Block 3A Central Park – Response to Submissions

Project Application (MP_11_0089)

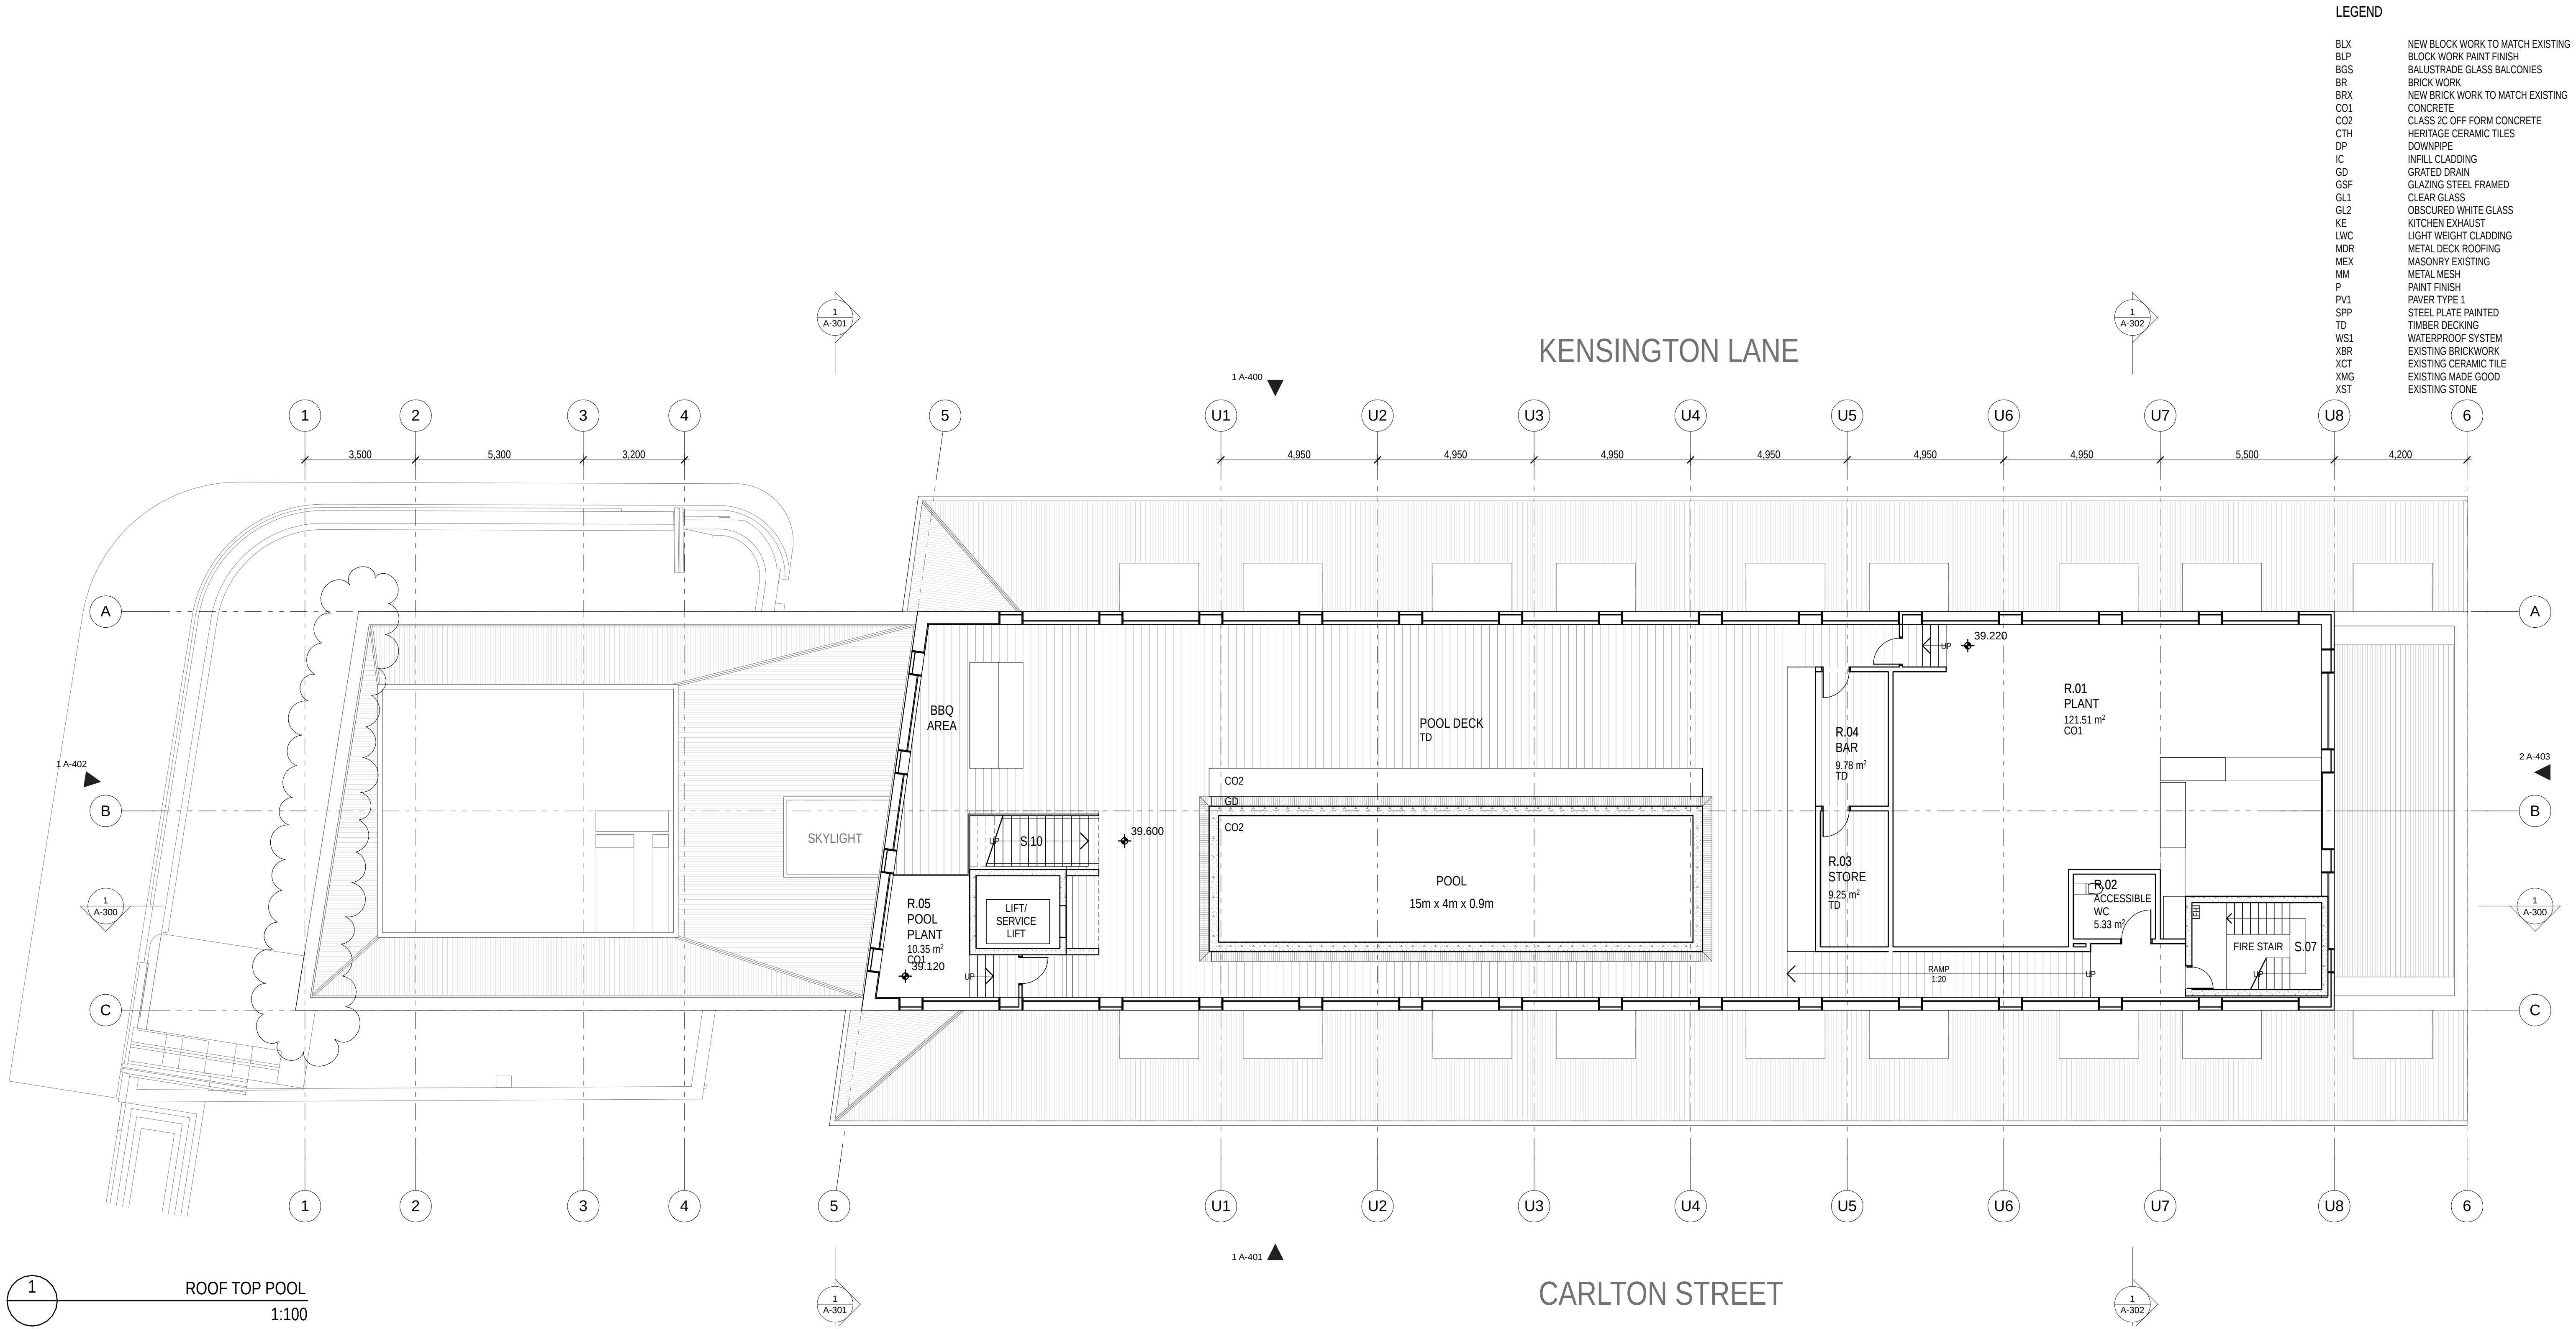
Building Setback (Clare Hotel Addition)	
The proposed form and setback of the additional floor above the Clare Hotel contribute to visual bulk particularly when viewed from the north. An increase in the northern setback and realignment of the addition to be parallel to the alignment of the Clare Hotel will reduce the visual impact of the when viewed from Broadway. It is therefore recommended that a minimum setback of 5 metres from the northern boundary be considered.	Frasers note that the proposed addition to the Clare Hotel is entirely consistent with the Concept Plan approved envelope, which was considered appropriate by the Department and Council at the time the Concept Plan was assessed. Notwithstanding this, Frasers is willing to increase the setback from a minimum of 3.6m (from the Broadway alignment on the eastern edge) to 5m. This is reflected in the revised Architectural Drawings (refer to Appendix B).
